29 April 2022

**STATE SIGNIFICANT INFRASTRUCTURE APPLICATION
Response to Stage *Response to Submissions*
SSI-8609189
Upper South Creek Advanced Water Recycling Centre**

Figure 1: Updated impact area and impact assessment area

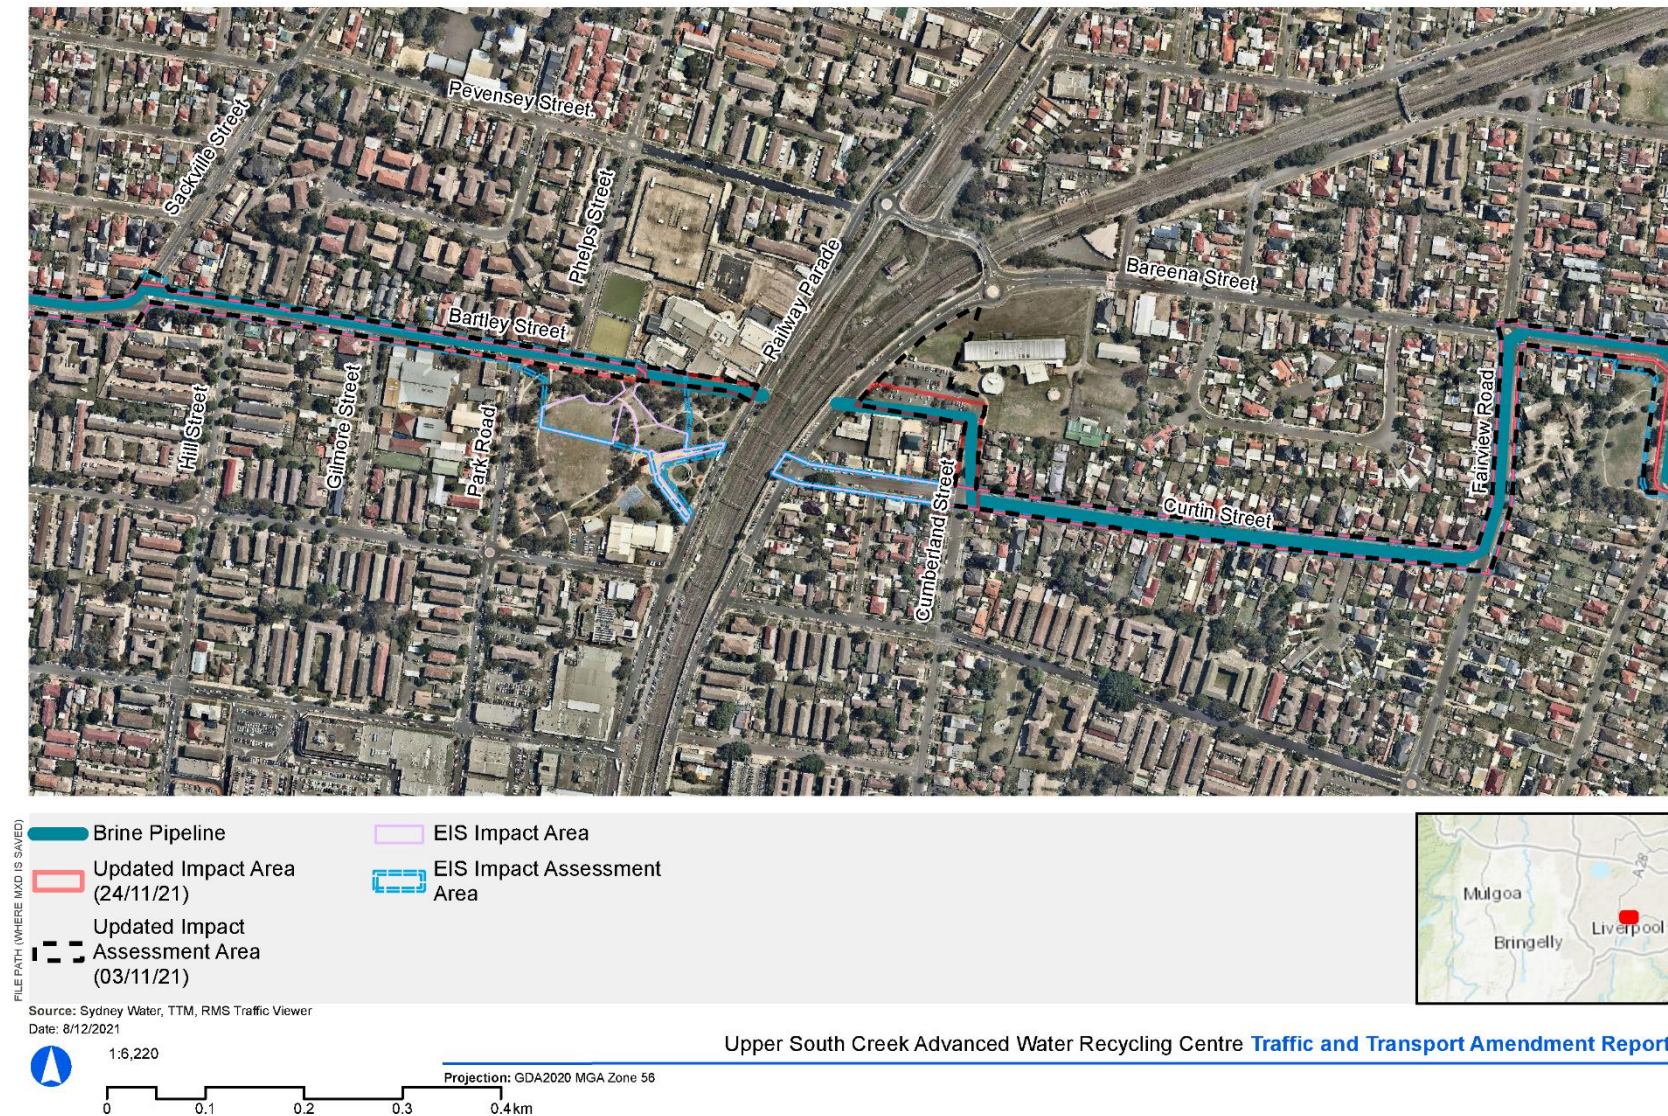
- The Brine Pipeline alignment at Cabramatta (Bartley Street realignment) is proposed to connect the AWRC to Sydney Water's existing wastewater system via Sydney Trains operational rail corridor and TAHE land between Cumberland Street and Bartley Street.
- As the proposed Brine Pipeline is to be tunnelled under Sydney Trains operational rail corridor and TAHE land, sufficient Land Owners Consent and related approval(s) must be obtained and in place prior to determination.
 - Further, the pipeline crossing under the rail corridor must meet the requirements of Transport standard T HR CI 12190 ST Service Installations within the Rail Corridor (copy attached).
- Lastly, due to the presence of South Sydney Freight line (SSFL) within the rail corridor, ARTC are also to be consulted by the Applicant.

To meet Sydney Trains requirements and obtain the relevant approvals, the Applicant is requested to contact Sydney Trains via email at DA_sydneytrains@transport.nsw.gov.au.
